# CITY OF ALBUQUERQUE

RE: **Chick-Fil-A @ Coors Pavilion**  
**Coors Pavilion, Lot 6**  
**Conceptual Grading and Drainage Plan**  
**Engineer's Stamp Date: 11/22/17**  
**Drainage File: G11D069C**

Based on the information provided in your submittal received 12/4/17, the Conceptual Grading and Drainage Plan cannot be approved for Site Plan for Building Permit until the following are addressed:

EXHIBIT A

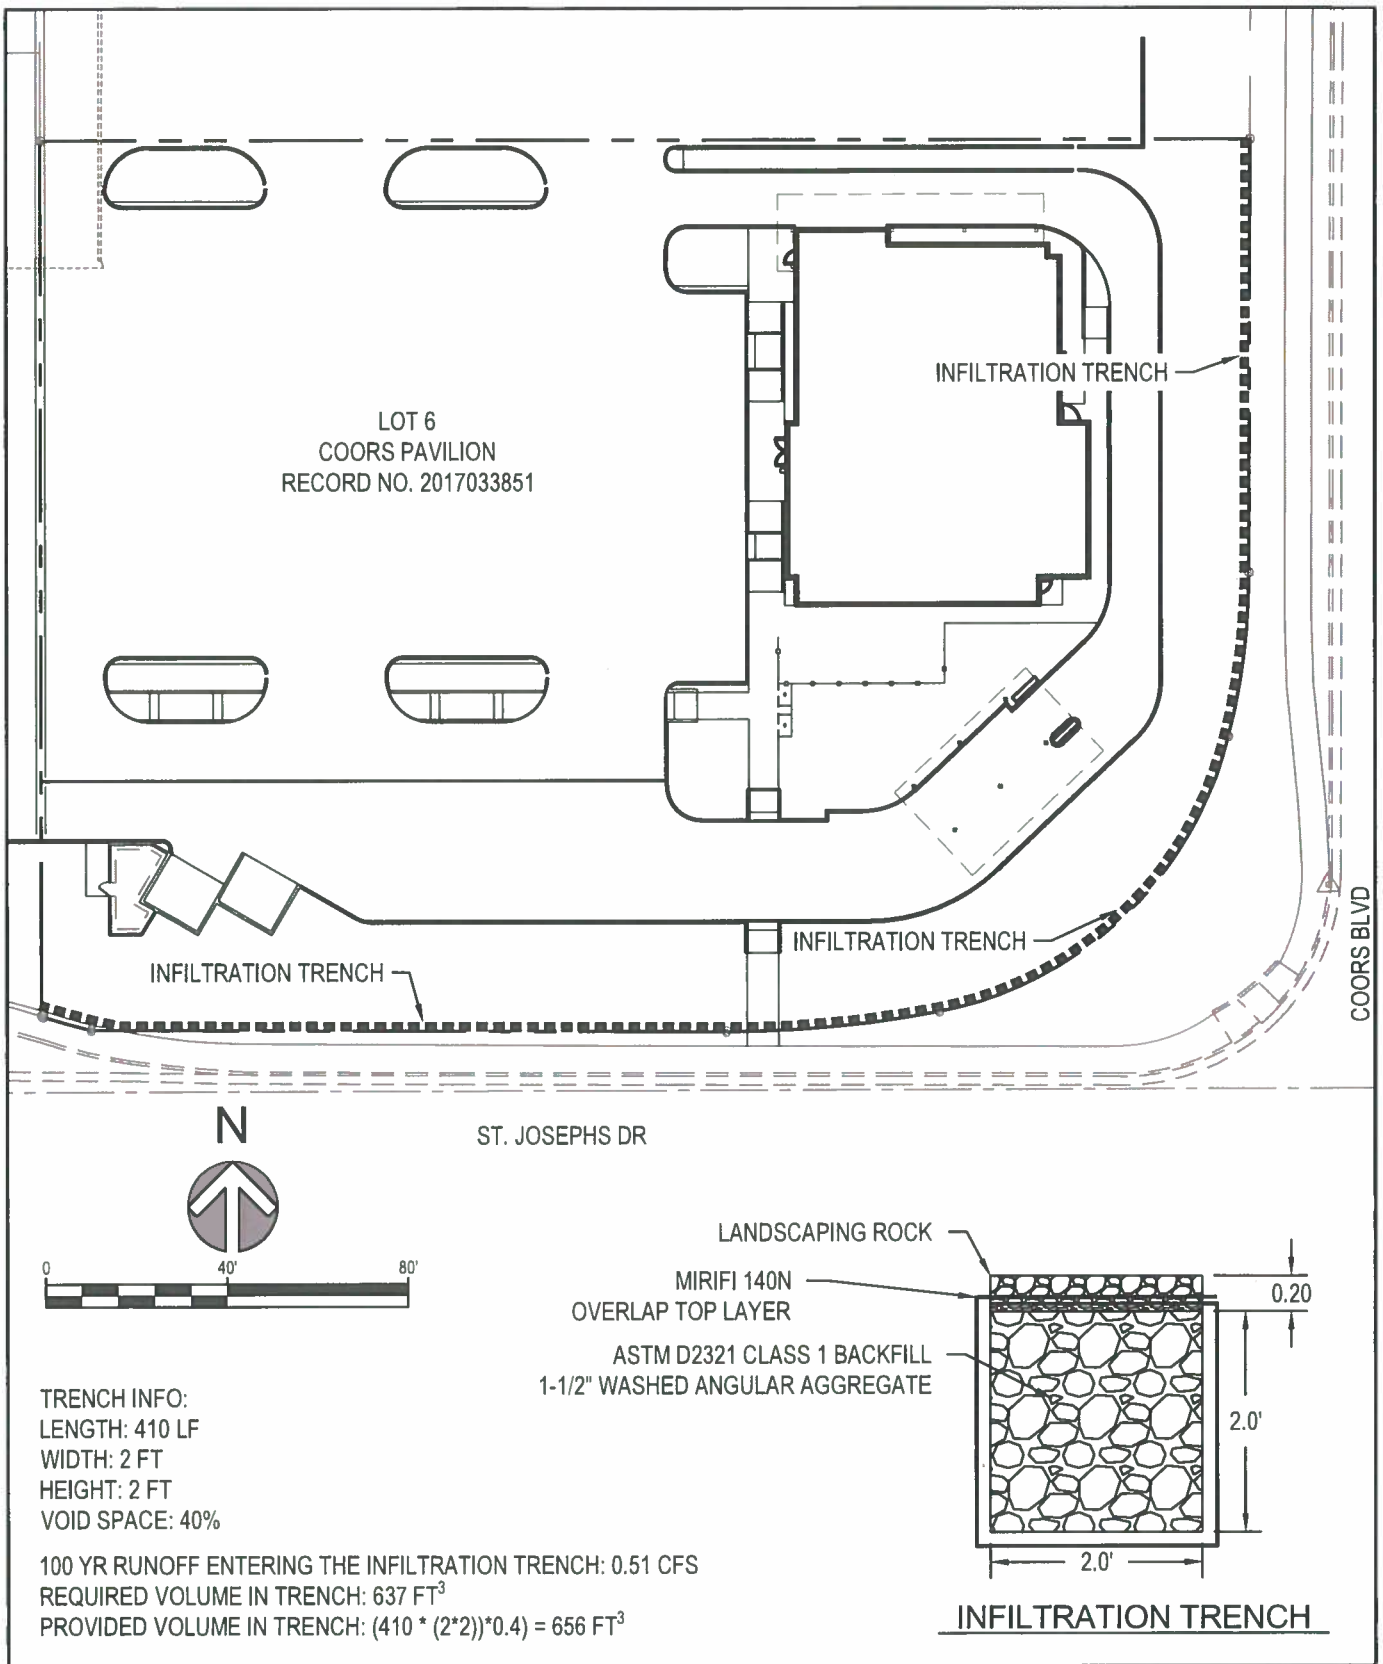
1. Provide a basin map with land treatments, areas, peak runoff, and runoff volume for each subbasin.
2. St. Josephs Drive does not have drainage capacity; no increased runoff to overcapacity systems can be authorized per § 14-5-2-12 (G) of the Albuquerque Code of Ordinances.

3. This plan proposes to discharge a portion of the site to Coors Blvd, an NMDOT road. Written concurrence must be obtained from NMDOT District 3 Drainage that this project can proceed or the. Please contact Tim Trujillo P.E (TimothyR.Trujillo@state.nm.us).

4. If the subbasins draining to the above two roads cannot be rerouted to the subdivision pond or approved by NMDOT (Coors), on-site ponding of the 100-year, 10 volume will be required for these subbasins.

5. Property line and limits of grading do not appear to match the legend. Please verify line-types and update the legend.
6. This project appears to show grading, paving, landscaping, and pond construction across the property line. Written permission must be obtained from the adjoining landowner for this work.

7. For trash enclosures serving food service developments, please include a drain line to a grease trap and then drain into the sanitary sewer. If this information is on the utility plan please provide it, or show on the grading plan.
